**COMMUNITY SERVICES DEPARTMENT**

March 11, 2022

**Subject: Homestead North at Sterling Ranch Phase I Preliminary Plan, Review #4 (SP-20-008)**

SECTION 27, 28 AND 33, IN TOWNSHIP 12 SOUTH, RANGE 65 WEST OF THE 6TH PRINCIPAL MERIDIAN, EL PASO COUNTY, COLORADO

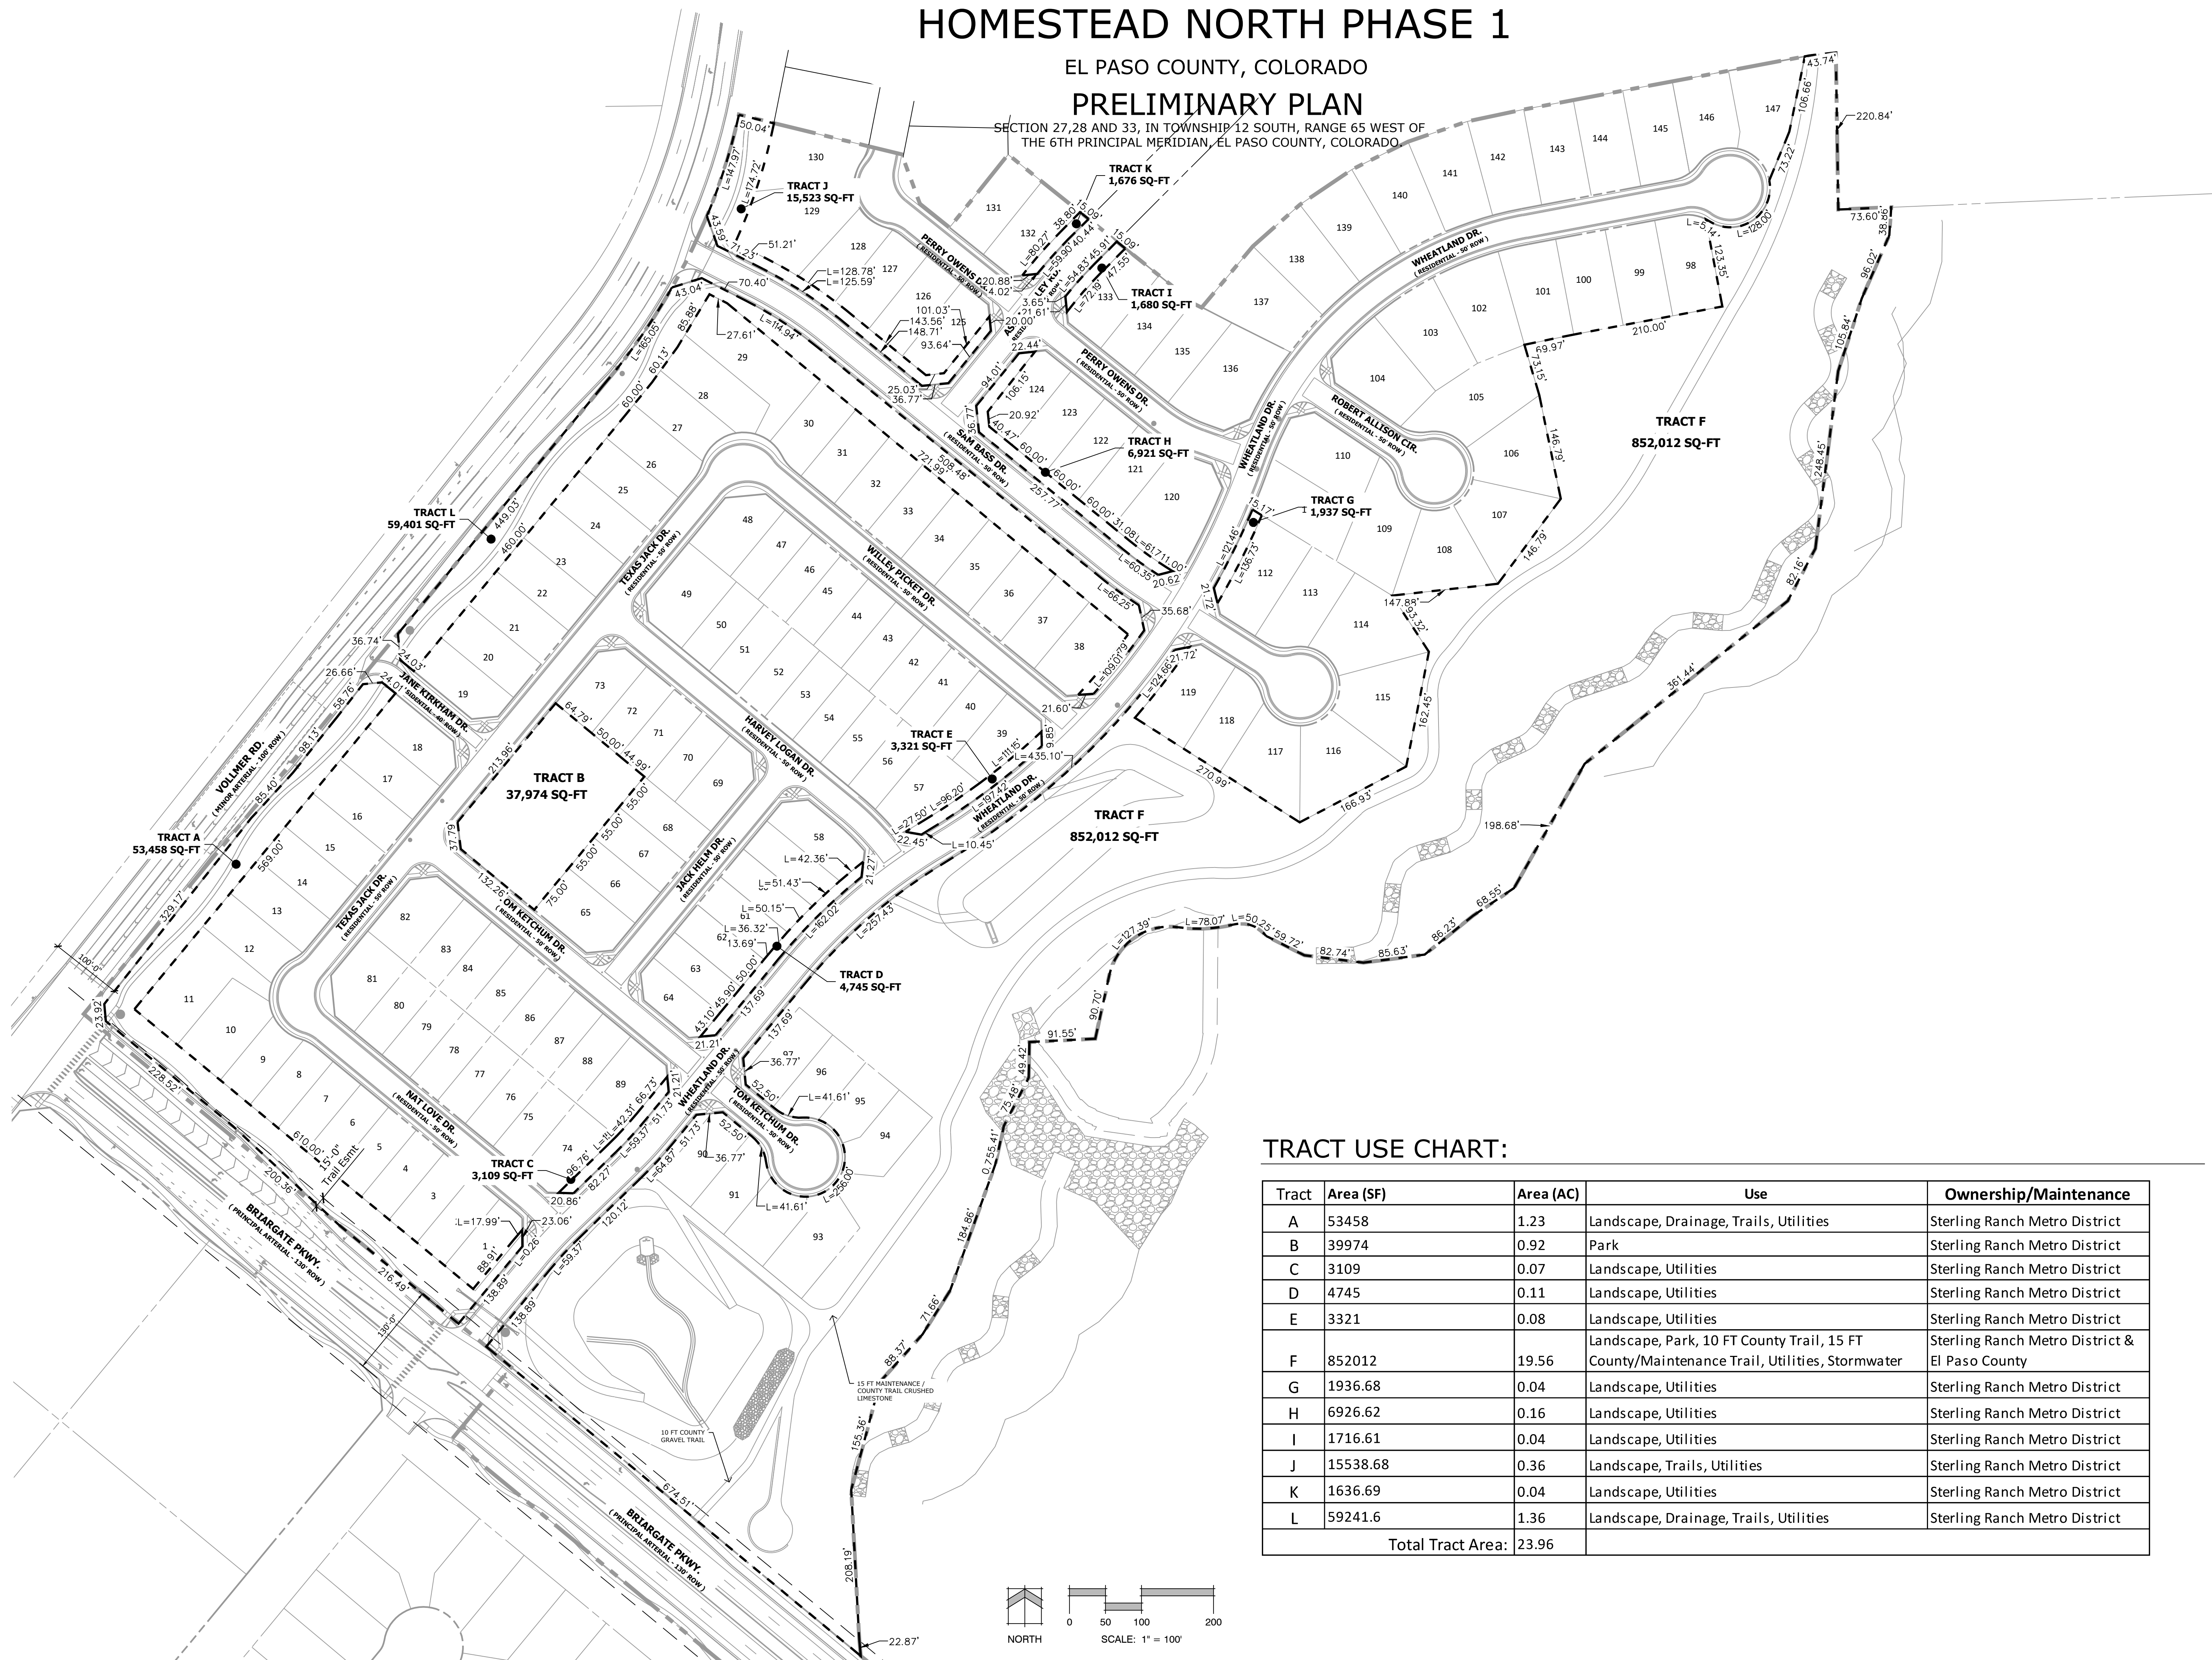
The Park Operations Division of the Community Services Department has reviewed the Homestead North at Sterling Ranch Phase I Preliminary Plan, Review #4, development application and has the following additional comments of behalf of El Paso County Parks. Since the previous comments were submitted (see below), El Paso County staff met with the applicant's representative and finalized the Sand Creek Primary Regional Trail along the western bank of Sand Creek within the bounds of the previous and currently submitted Sterling Ranch preliminary plans and final plats. The applicant has addressed staff's previous concerns, and the current Preliminary Plan submittal once again shows and labels the Sand Creek Regional Trail through Homestead North Phase I, and the aforementioned discussions confirmed the trail crossing of Briargate Parkway at Wheatland Drive, as the Sand Creek underpass cannot accommodate the trail alignment due to the tight confines of the Sand Creek channel realignment process.

*"EPC Parks staff continues to note the absence of the Sand Creek Regional Trail from the Preliminary Plan cover sheet and all additional sheets included with the Preliminary Plan. While a trail or road is shown in the Preliminary Plans, it is labeled as a "15' Maintenance Trail" and does not continue south of Briargate Parkway. The General Notes section does mention that trails labeled as "County Regional Trail" will be maintained by El Paso County, but none exist on this iteration of the Preliminary Plan.*

*“Staff questions the removal of the Sand Creek Regional Trail alignment and labeling from the Preliminary Plan, particularly on the cover page and Site Plans. The included utility and grading plans do show what appears to be the Sand Creek Regional Trail, but there are no labels indicating it as so. As noted in the following comments and recommendations, as endorsed by the Park Advisory Board on January 13, 2021, EPC Parks is requesting a 25’ trail easement for the construction and maintenance of the Sand Creek Regional Trail. Staff also requests clarification as to the number of neighborhood parks proposed for Homestead North. The current Letter of Intent mentions one 0.87-acre park located in Tract B, but also indicates a park in Tract F. The location of the Tract F park is not indicated in the Preliminary Plan. Furthermore, staff acknowledges the increase in Preliminary Plan acreage from 60.6 acres to 77.7 acres due to the inclusion of the eastern and southern extensions of Briargate Parkway and Sterling Ranch Road, respectively.”*

*The proposed Sand Creek Regional Trail is depicted in the Preliminary Plan, and labeled as “10’ County Gravel Trail,” although when constructed, the trail will follow EPC Parks Tier I Trail standards with an 8’ wide crusher fine trail surface with 2’ natural shoulders. The Preliminary Plan also shows concrete sidewalks/trails located adjacent Vollmer Road and the future Briargate Parkway extension. These non-County trails will allow for direct off-street connectivity to the Sand Creek Regional Trail for the residents and visitors of Sterling Ranch.*

*Due to the location of the Sand Creek Primary Regional Trail within the Homestead North at Sterling Ranch Phase I development, El Paso County Parks staff recommends that the applicant designate, provide, and dedicate to El Paso County a 25-foot trail easement that allows for the construction, maintenance, and public access of the regional trail. Furthermore, staff recommends fees in lieu of land dedication for regional and urban park purposes.*

*The Park Advisory Board recommends that the Planning Commission and the Board of County Commissioners include the following conditions when considering and/or approving the Homestead North at Sterling Ranch Phase I Preliminary Plan: (1) designate and provide to El Paso County a 25-foot trail easement through Homestead North at Sterling Ranch, within Tract F, that allows for construction, maintenance, and public access of the Sand Creek Primary Regional Trail, and dedicate the easement to El Paso County prior to the recording of the forthcoming final plat(s); 2) include descriptions, drawings, and locations of the two neighborhood parks in the Letter of Intent and Preliminary Plans, respectively; 3) fees in lieu of land dedication for regional park purposes in the amount of \$68,649 and urban park fees in the amount of \$43,365 will be required upon recording of the forthcoming final plat(s). A Park Lands Agreement may be an acceptable alternative to urban park fees, provided the agreement is approved by the County and executed prior to recording the forthcoming final plat(s)."*
